RE: DENDROBIUM MINE – WATERNSW RESPONSE TO SUBMISSIONS REPORT

In response to DPIE's letter dated 20 April 2020, please find enclosed (Enclosure 1) South32's responses to residual concerns raised by WaterNSW in its submission on the *Dendrobium Mine – Plan for the Future: Coal for Steelmaking EIS* (the Project) and Submissions Report (letter dated 6 March 2020). Additional supporting information is provided in the enclosed letters prepared by MSEC (Enclosures 2 and 3).

RESPONSE TO WATERNSW COMMENTS

The alternate width mine layouts are shown in Figures 2.3 to 2.9.

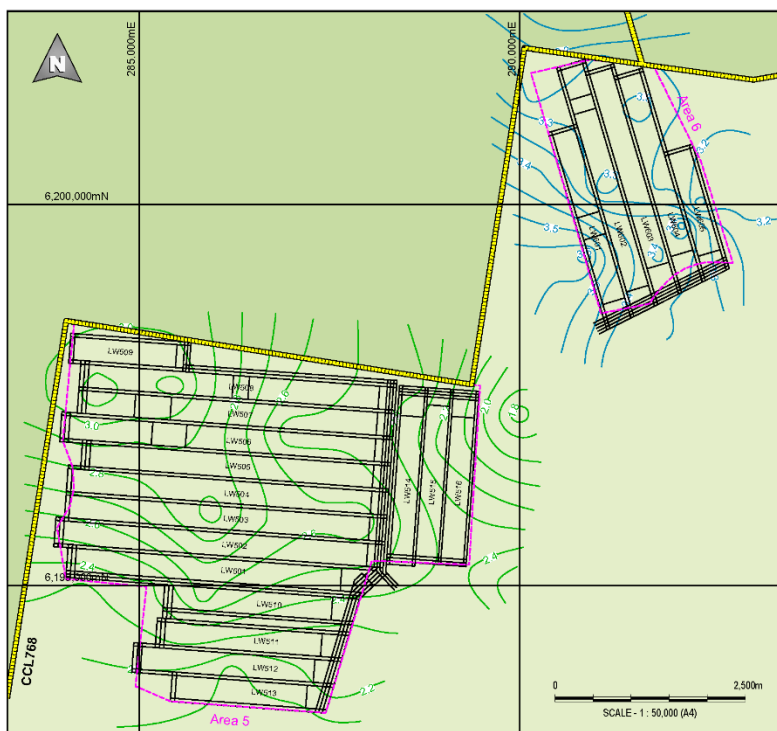
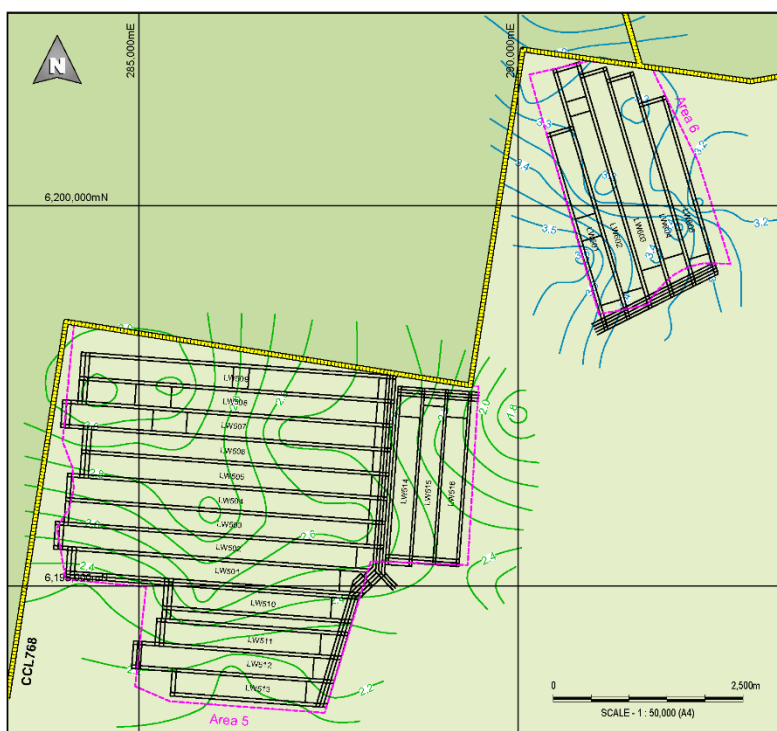
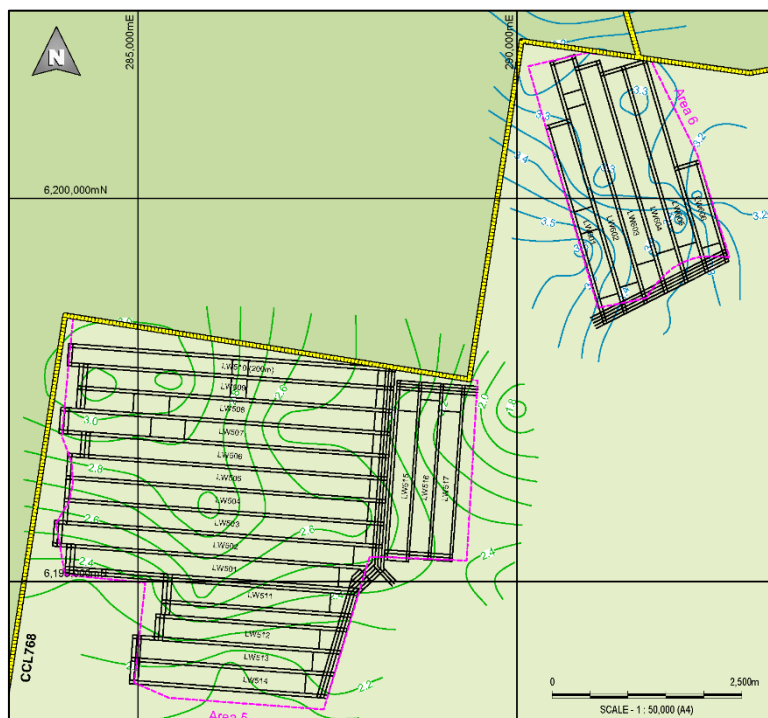
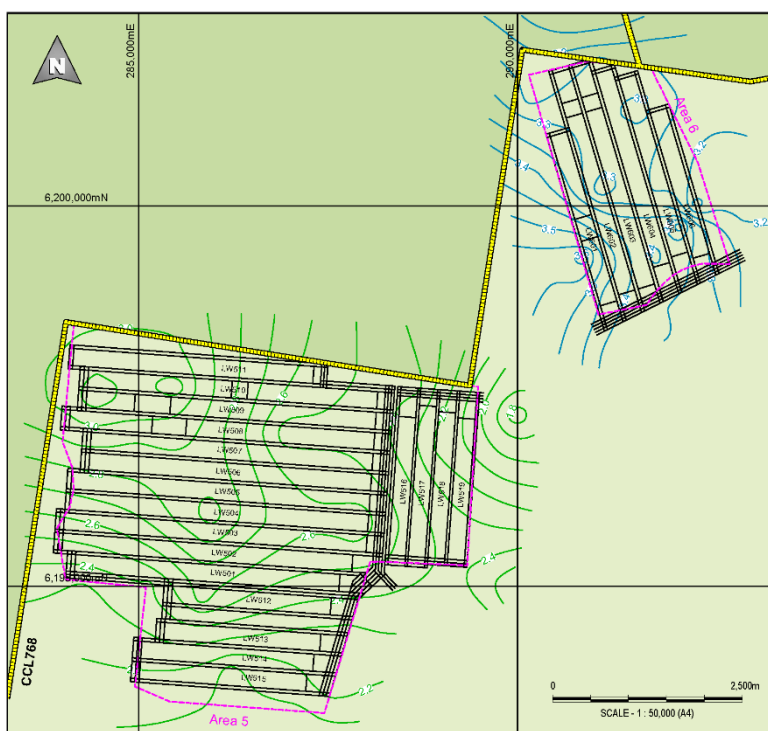
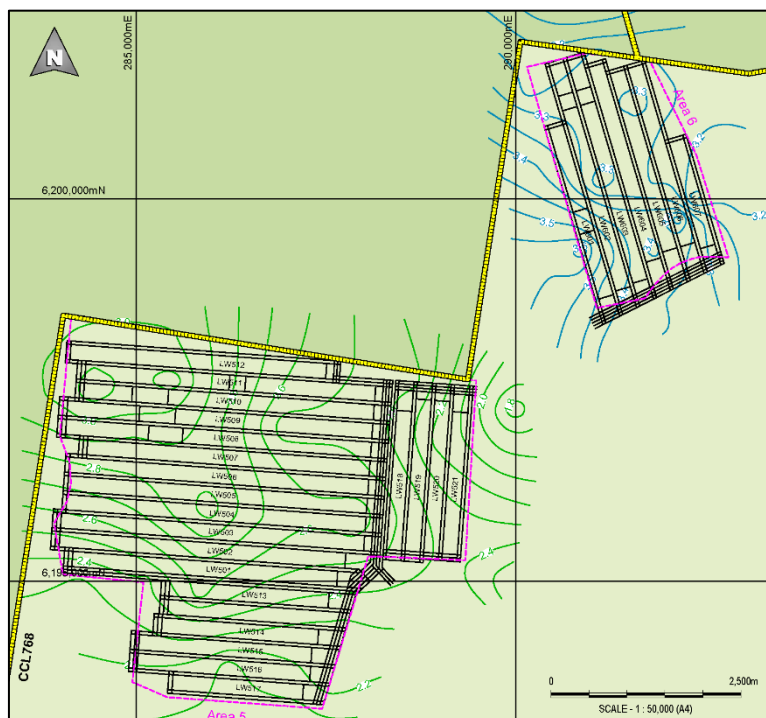
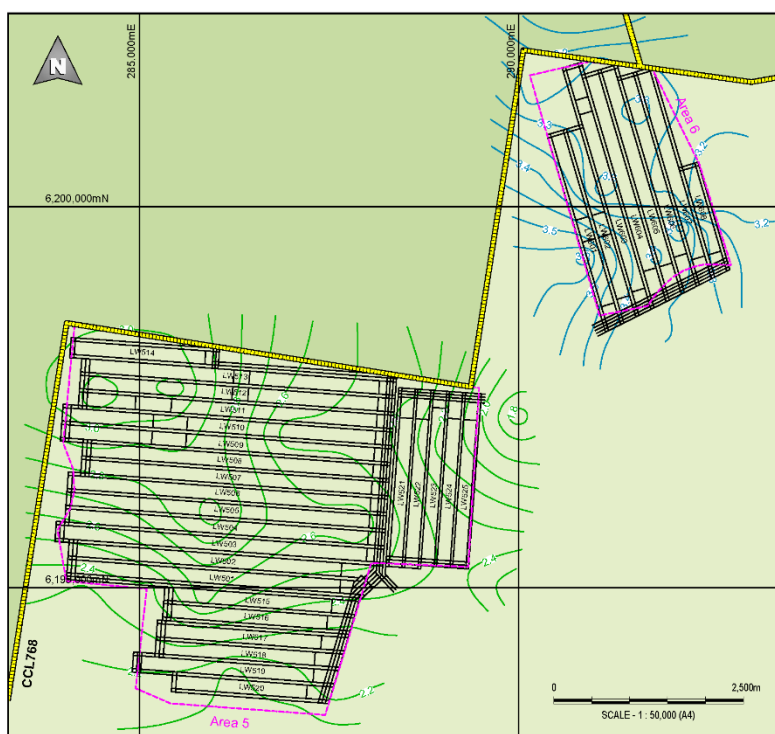
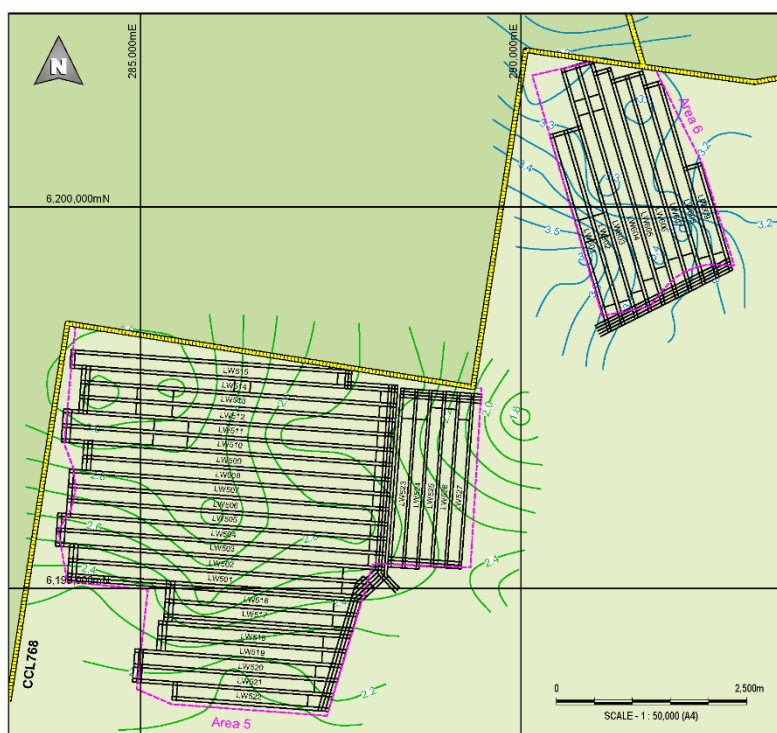
WaterNSW notes that the RTS makes an unsubstantiated statement that adverse environmental impacts are still anticipated for reduced longwall widths down to approximately 150 metres. No reports or data are provided to support this claim.

South32 should be required to provide detailed information on the environmental risk profile from increasing incremental widths of longwalls (e.g. 100 metres, 150 metres, 200 metres and 250 metres).

The comment that adverse environmental impacts at the surface would occur due to subsidence-related effects for panel widths of 150 m is based on advice from MSEC (2019a) (Enclosure 2).

MSEC (2019a) has undertaken analysis of longwall widths of 150 m at the Dendrobium Mine (Enclosure 2), concluding:

.. The predicted conventional strains for the 150 m through to 305 m wide longwalls are greater than 0.5 mm/m tensile and 2 mm/m compressive. Whilst the predicted strains and, hence, the potential for physical impacts decrease with narrower longwall widths, the strains are still of sufficient magnitude to result in the fracturing of bedrock.

Consequently, while narrower longwall panels would reduce total vertical subsidence, and correspondingly reduce predicted tilts and strains, the strains due to the valley-related effects would still be sufficient to result in fracturing of rockbars, pools and bedrock above and adjacent to the longwalls (i.e. adverse environmental impacts are still anticipated for reduced longwall widths down to approximately 150 m). More detail is provided in MSEC (2019a) (Enclosure 2).
